To: Michel Kearney, P.Geo. – City of Ottawa
From: Rob Kell, M.A.Sc., P.Eng., P.Geo., Dillon Consulting Limited
cc: Brent Loney, M.Sc., P.Geo., Dillon Consulting Limited
Date: May 15, 2020
Subject: Review of Caivan - ABIC - Groundwater Field Investigation Memo
Our File: 20-2859

As requested, Dillon has completed a review of the memo prepared by the Paterson Group, titled "Groundwater Field Investigation, Proposed Warehouse Complex - 3713 Borrisokane Road – Ottawa", May 13, 2020. The Paterson memo provides a summary of a field program to assess groundwater elevations at the east side of the subject site and an assessment of the potential for construction dewatering for the construction of the infiltration gallery and septic proposed for the site. The memo indicates that the base elevation of the proposed infiltration gallery will be at 97.5 masl and the base elevation of the septic tank will be higher than 99.0 masl.

TEST HOLE LOCATION PLAN

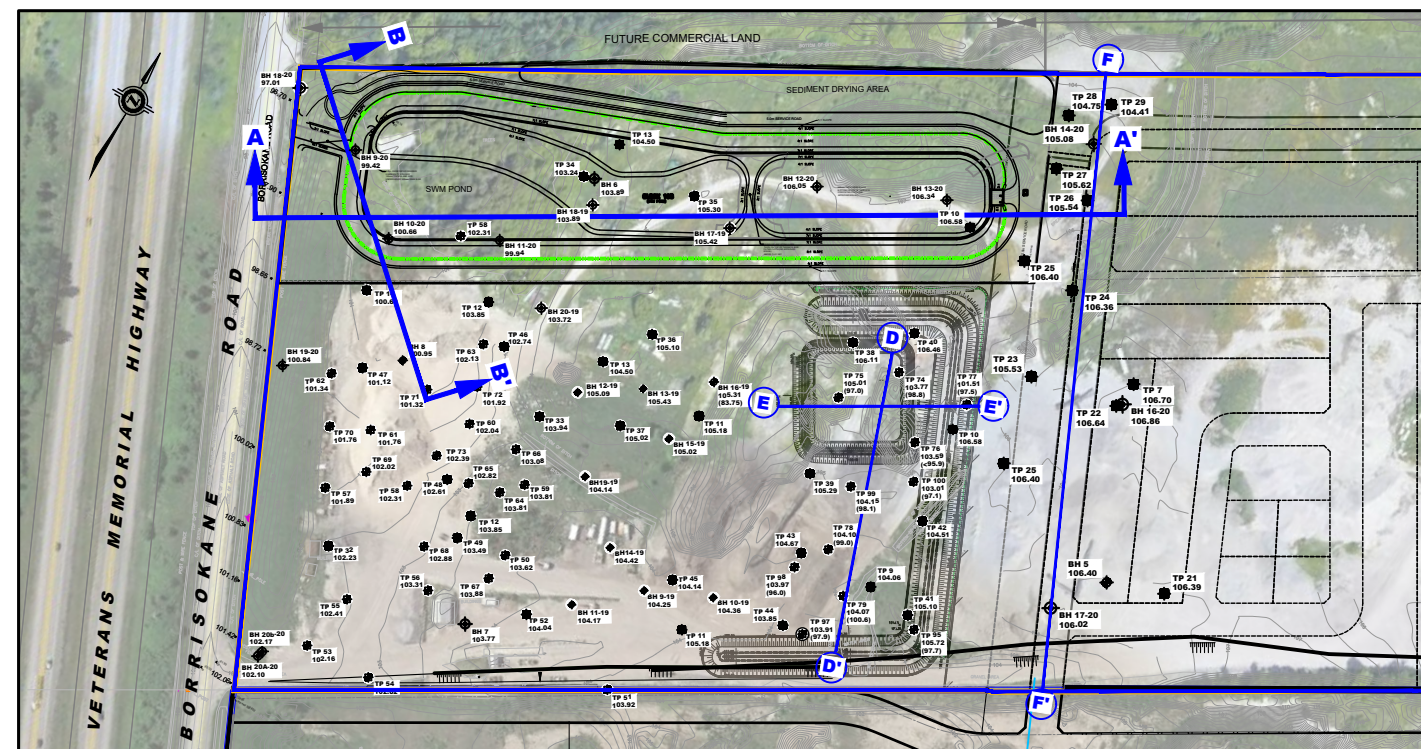
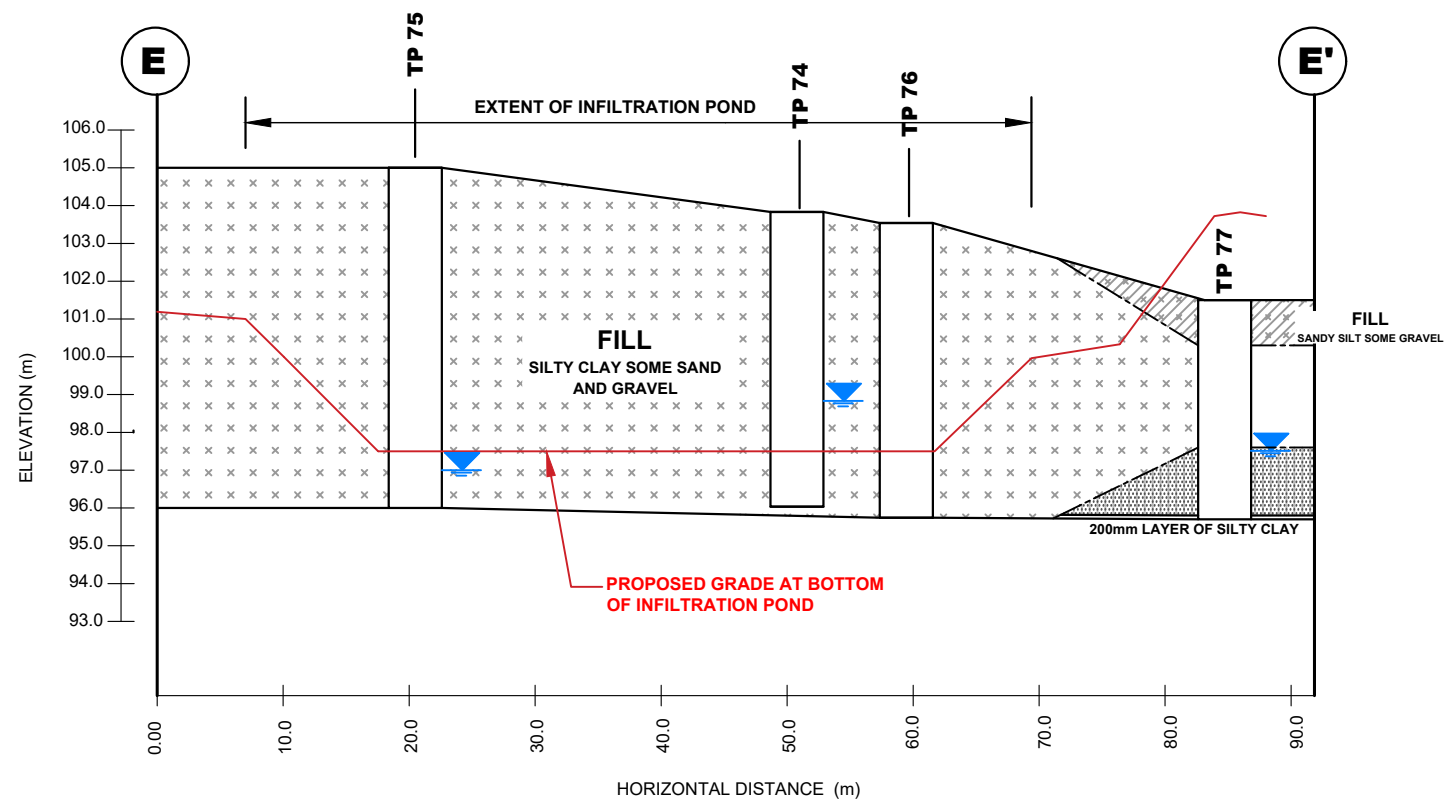
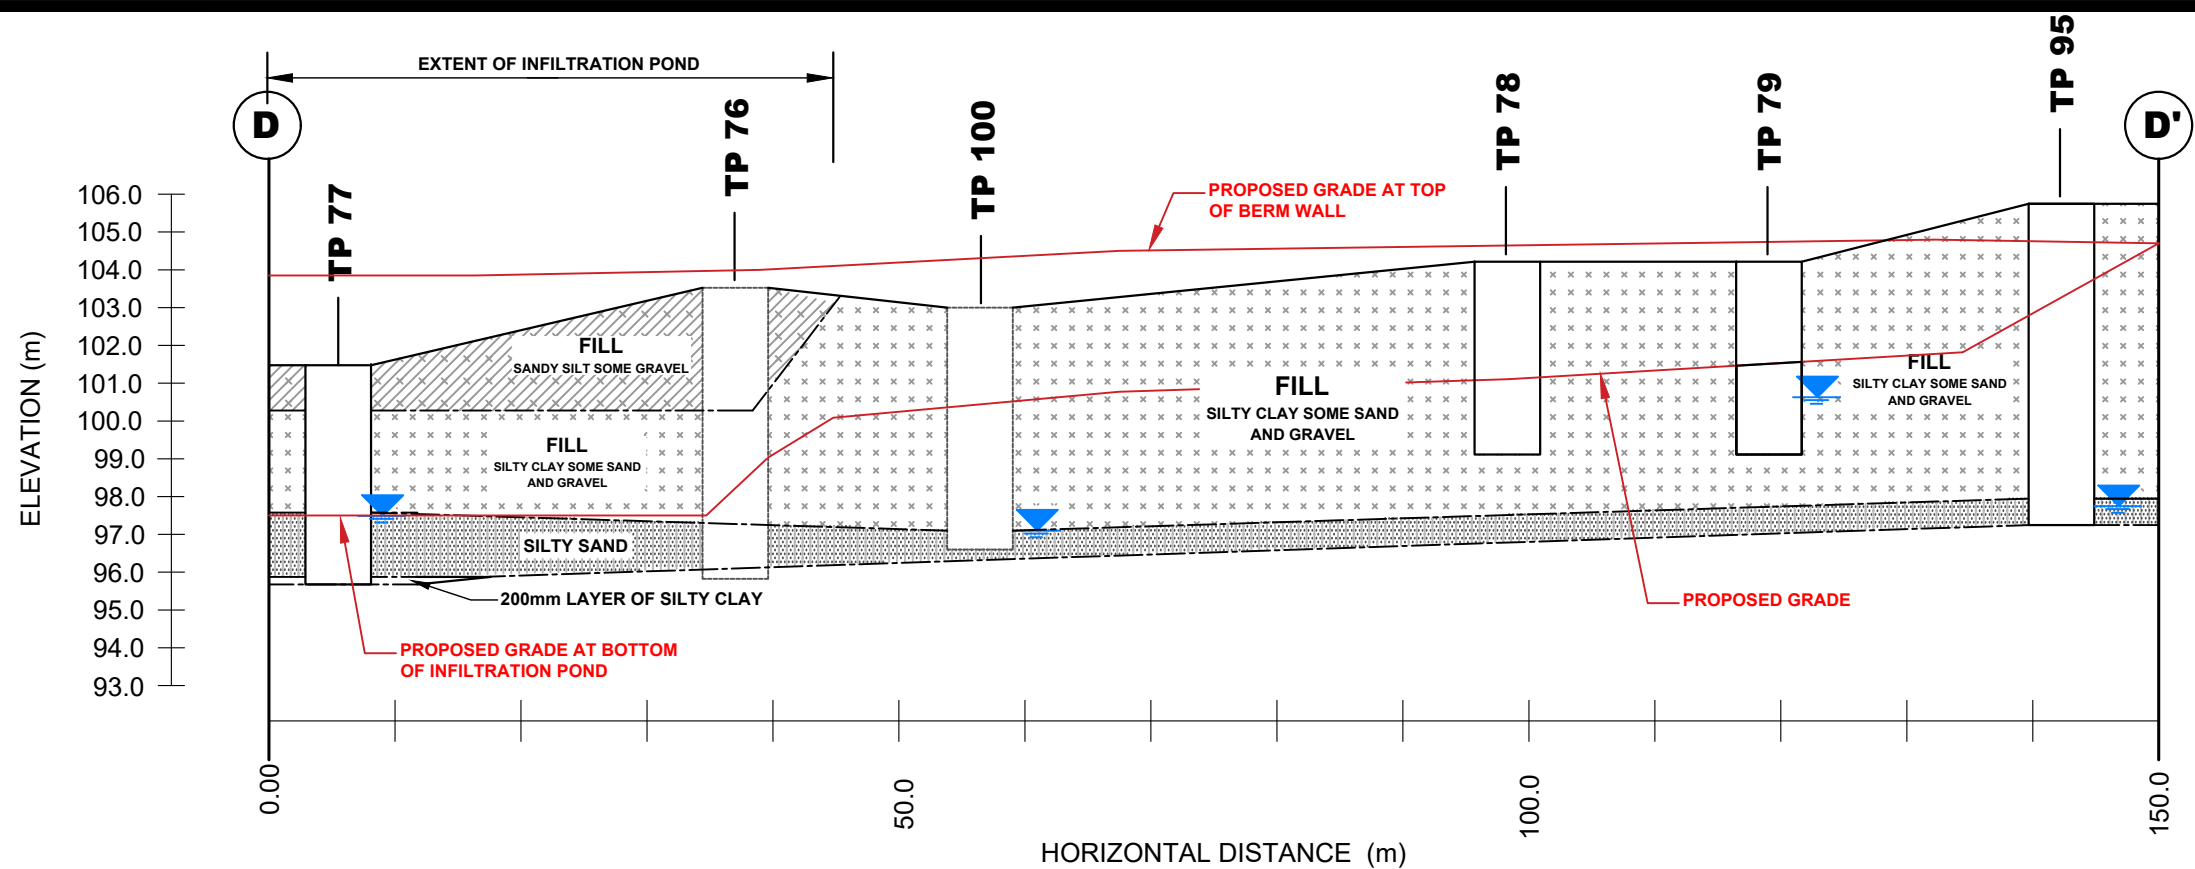
With the exception of one test pit (TP74), inferred groundwater levels in the test pits were at or below the bottom elevation of the proposed infiltration gallery 97.5 masl. The water level at TP74 was at 98.8 masl, 1.3 m above the bottom excavation of the proposed infiltration gallery. The higher water level at this test pit was attributed by Paterson to lower hydraulic conductivity fill material noted within the test hole. Paterson states that the lower hydraulic conductivity fill material in the area " ... contains limited groundwater" and concludes that construction dewatering is not expected to be required when constructing the infiltration gallery. We assume that Paterson meant that these materials would conduct less groundwater, such that construction dewatering requirements would be minimal. Dillon has reviewed the groundwater conditions in this general area which indicate that interpolated groundwater levels are generally at an elevation of 97.5 masl (corresponding to the bottom elevation of the proposed Infiltration Gallery). As such, we have no information that would contradict the Paterson conclusion that construction dewatering is not expected to be required.

Although not within the construction dewatering assessment, we note that the water table is expected to be at or near the bottom of the infiltration gallery and there will be limited unsaturated soil beneath the infiltration system. As such groundwater mounding in the longer term should be expected in the vicinity of infiltration gallery and the groundwater mound will cause localized vertical and horizontal groundwater flow.

Test pit TP78 was excavated to a depth corresponding to the proposed bottom of the tank (99.0 masl). The test pit was dry and, as such, Patterson concludes that construction dewatering will not be required during the installation of the septic tanks. It is noted that the water level at TP79 (located approximately 25 m south of TP78) was at an elevation of 100.6 masl. Water levels at other test pits excavated nearby support a groundwater elevation less than 99.0 masl. As stated above, Dillon's review of the groundwater levels in this general area indicates levels less than 99.0 masl, and we have no information that would contradict the Patterson conclusion that construction dewatering is not expected to be required in the area of the septic tank.
